22 SHAD THAMES, LONDON SE1 2YU

APPLICATION FOR LISTED BUILDING CONSENT TO UPDATE THE DRAWINGS ATTACHED TO PARENT PLANNING PERMISSION REFERENCE 21/AP/3117 UNDER PLANNING (LISTED BUILDING AND CONSERVATION AREAS) ACT 1990, VIA PLANNING PORTAL: PP-12357726.

HERITAGE STATEMENT

“Listed Building Consent to make amendments to internal alterations to the building consented under application reference 21/AP/3117, including minor changes to MEP and services design, the glazed internal partition in the ground floor reception, the layout of W/Cs and the detail of the balustrade to the Level 05 infill, .”

Title  
Existing  
West Elevation

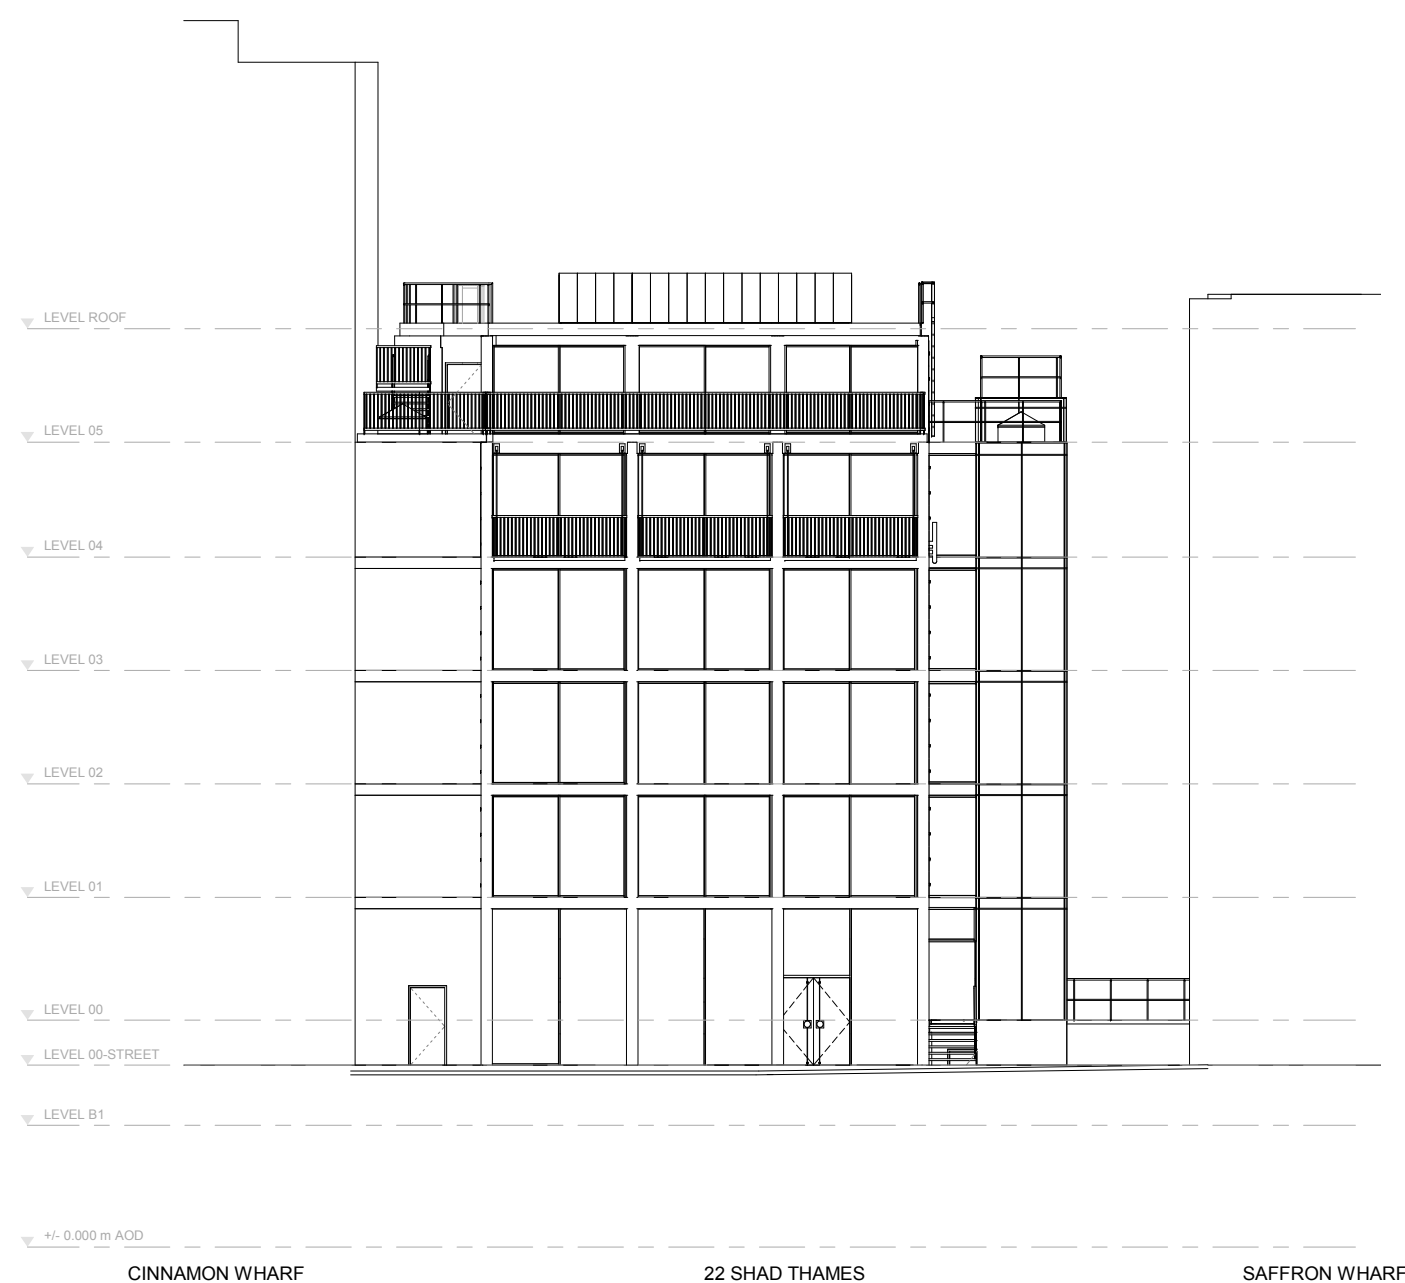
Redundant Services

It is proposed to remove the existing tap, grille, pipe connections and alarm siren on the west elevation. The openings will be infilled with a concrete finish to match the existing façade- creating a consistent aesthetic on the west elevation, whilst simultaneously removing redundant services.

Title  
Demolition  
Ground Floor Plan

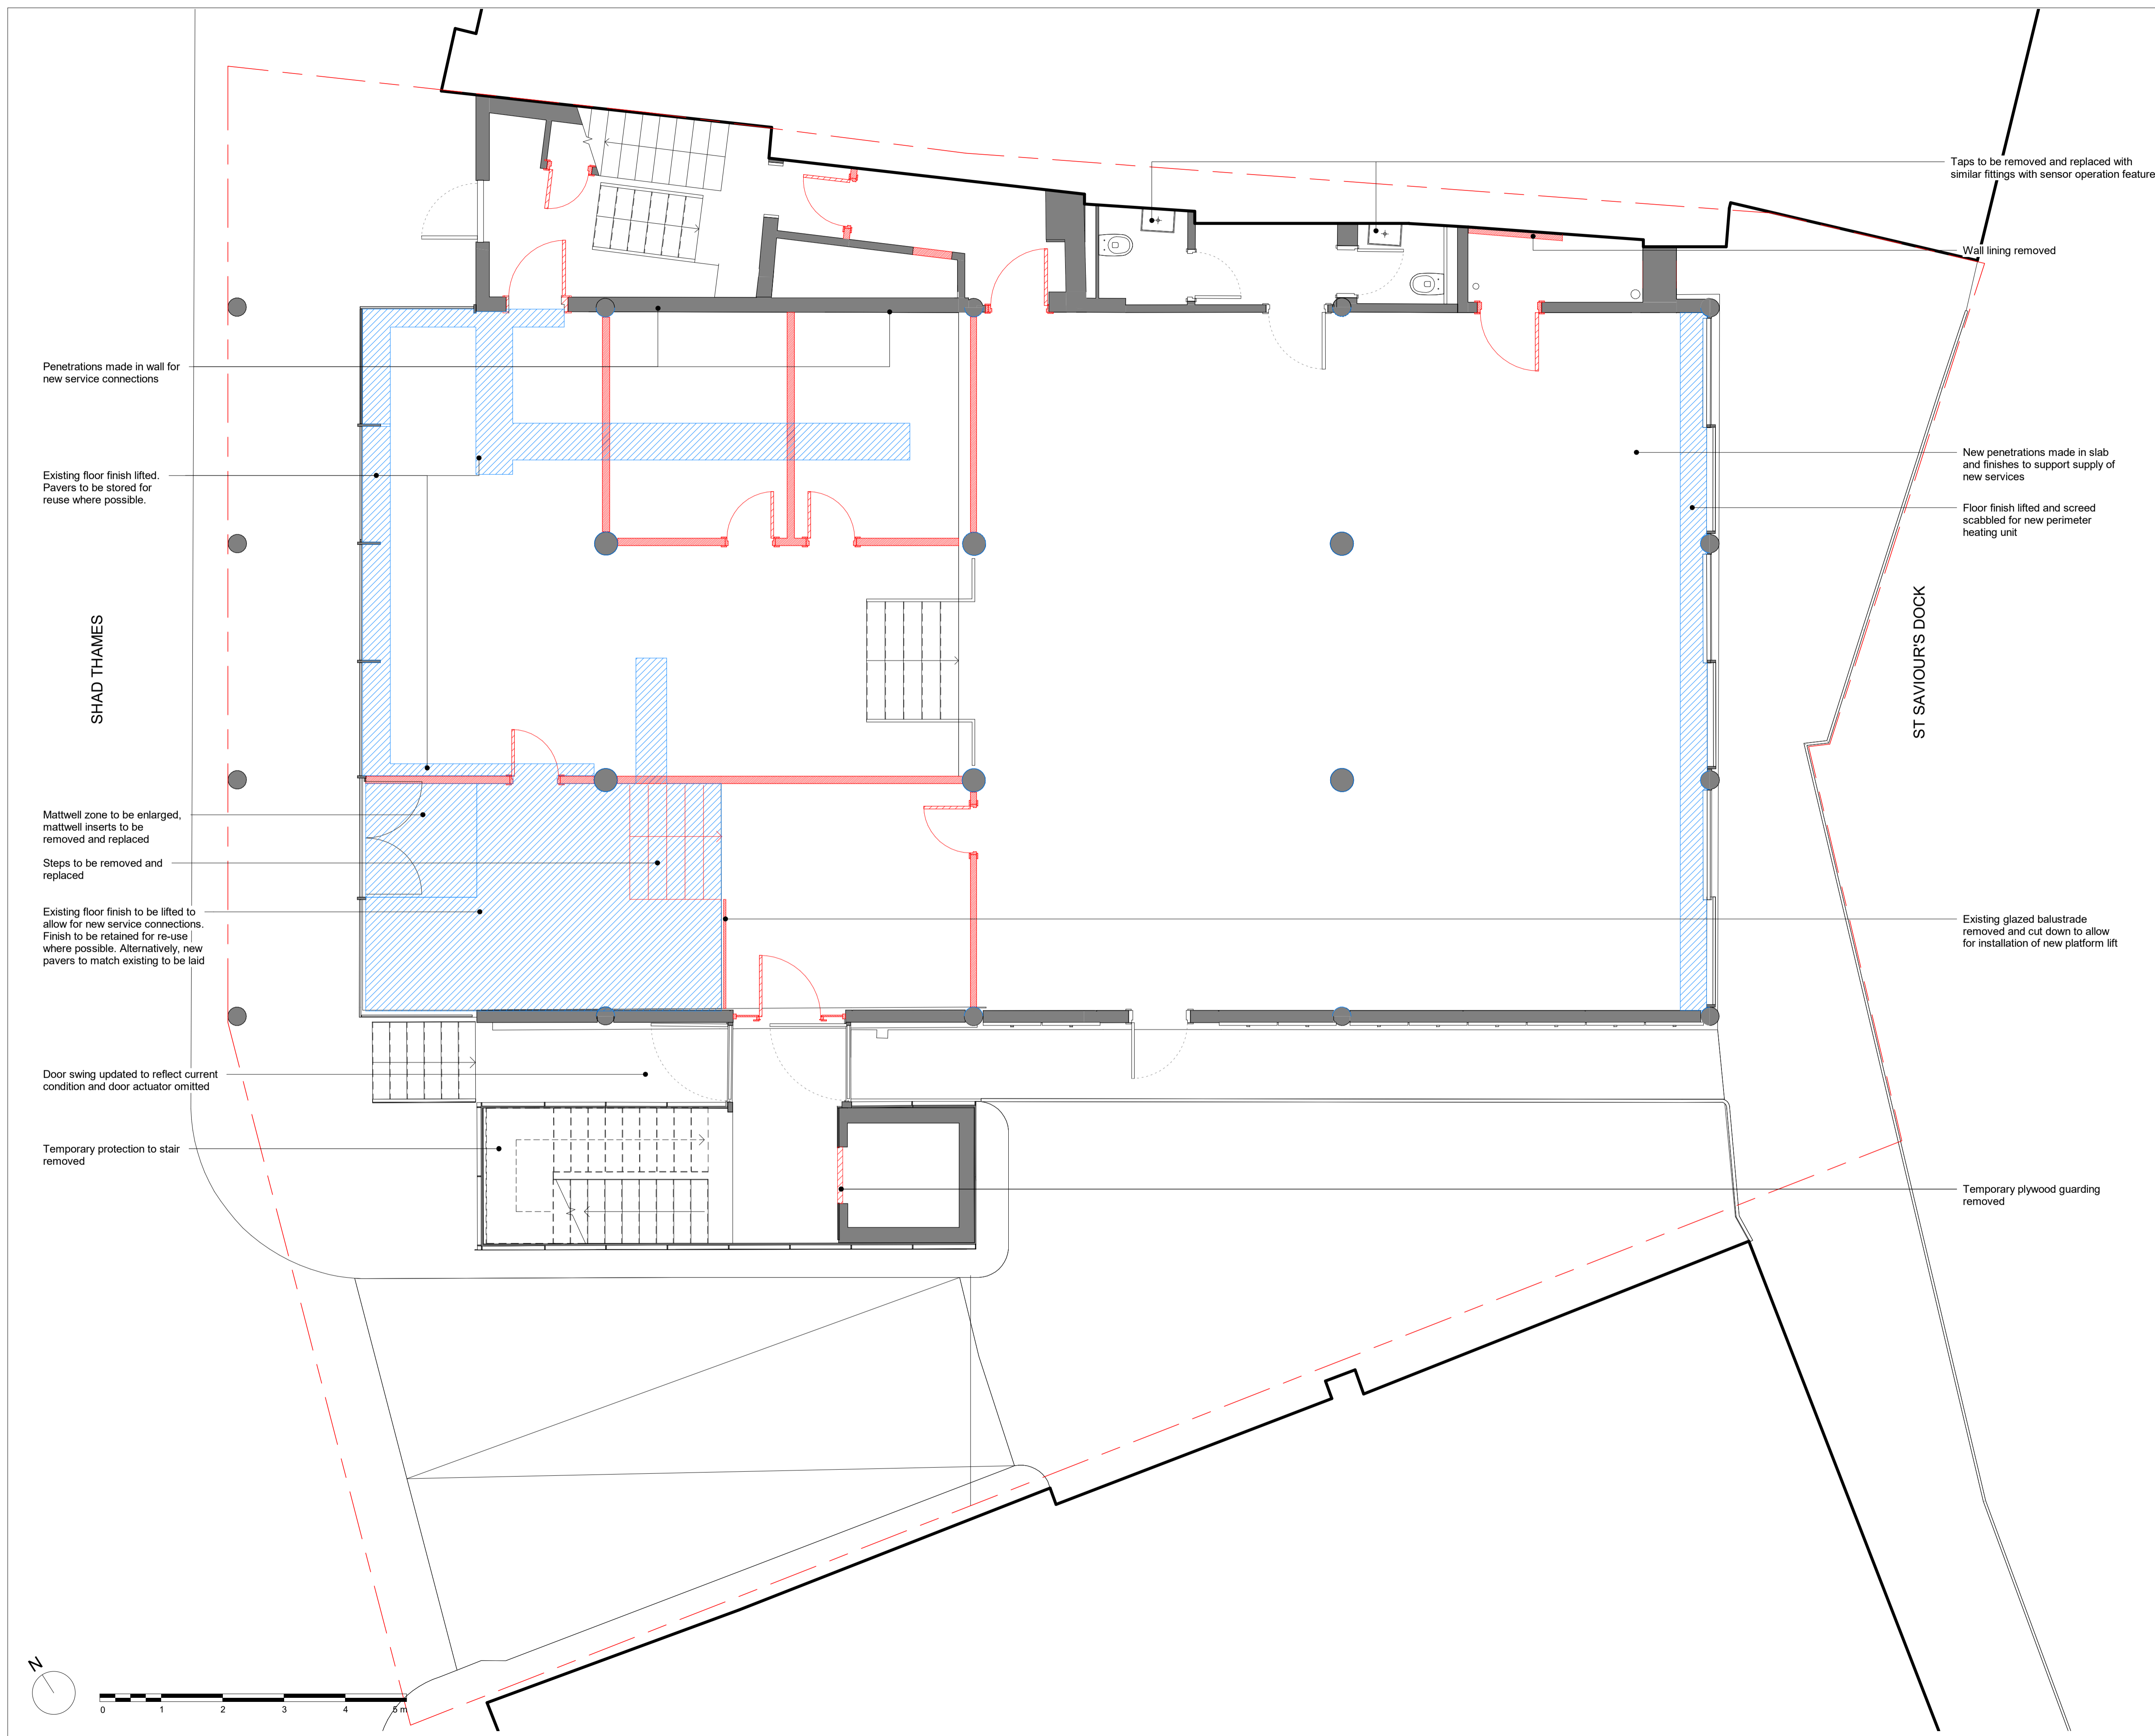
Trench Heating Extents

Upon inspection the screed at ground floor level was found to be shallower than originally expected. In order to accommodate this the MEP strategy for the perimeter trench heating unit has been adjusted. This alters the extents, width and location. The appearance remains unchanged from the consented trench heating unit.

The edges of the proposed new units will align with the back of the glazed façade fins. A single row of tiles along the façade edge will be lifted to enable these works. A small extension to the run is also proposed at both ends to improve access for ongoing maintenance and to provide a consistent level of heat across the façade.

To the north the connection will provide connection to a new boiler cupboard in the service core from which the heating unit will be served. The depth of the cupboard has been carefully aligned to an existing service bulk head at high level.

Entrance Doors to the South Core

Previous drawings illustrating the existing swing on the main entrance door were incorrect. The actuator to this door present on the consented drawings is no longer required and as such this has been removed from the drawings.

Floor Box Location Adjustment

The location of the floor boxes have been adjusted to suit the final furniture layout. Small adjustments were made to future proof the area and minimize future interventions on the existing building. The proposed changes are not seen to have any impact on the building and are in line with that which was previously consented. The new locations were highlighted to officers on the Site visit held on the 15th November 2023. The new positions were agreed, with former floor box locations to be tiled over.
